Subject: RE: 3/2012/1044 - Land adj to The Spinney

Planning Application No: 3/2012/1044

Proposals: Proposed construction of a new two-storey office development on redundant land adjacent to The Spinney, car park with hard and soft landscaping areas and service installations to suit

Sarah Gorman
Ecologist

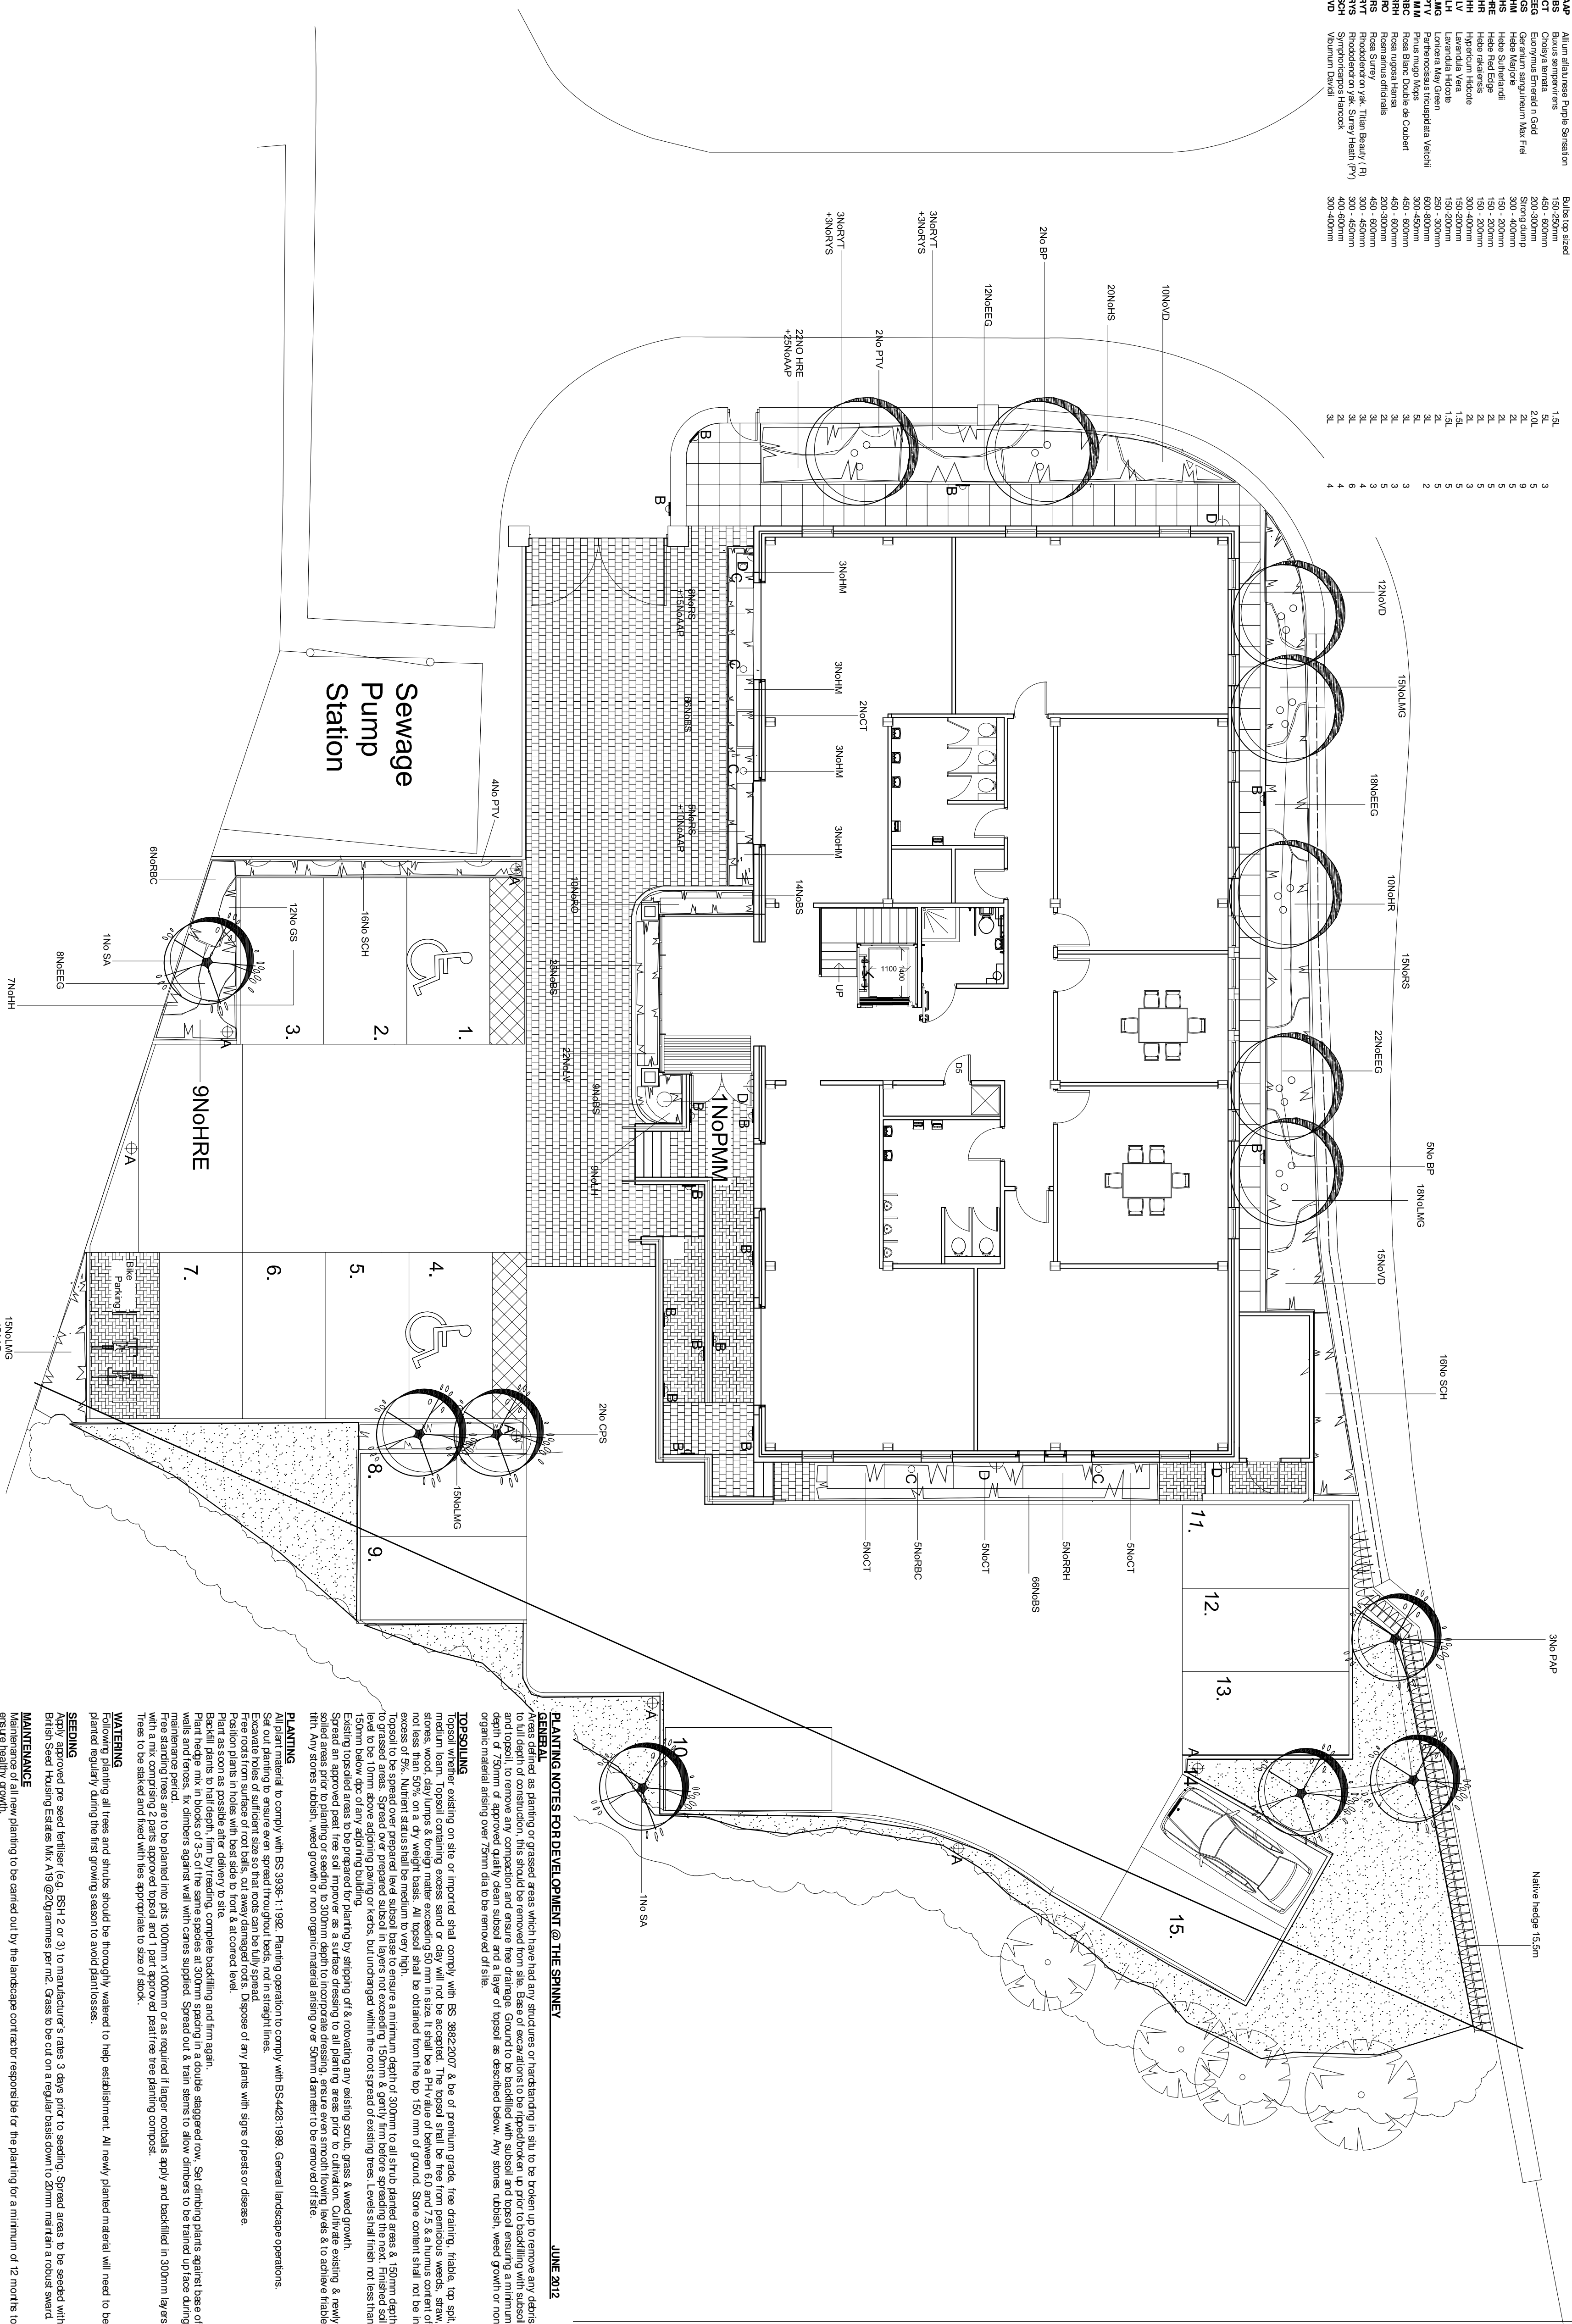
Adequate replacement planting should be incorporated into the plan to compensate for any loss of trees/shrubs. Appropriate guidance is given in Lancashire County Council's Supplementary Planning Guidance on Landscape and Heritage
<http://www.lancashire.gov.uk/corporate/web/view.asp?siteid=3654&pageid=11650&e=e>
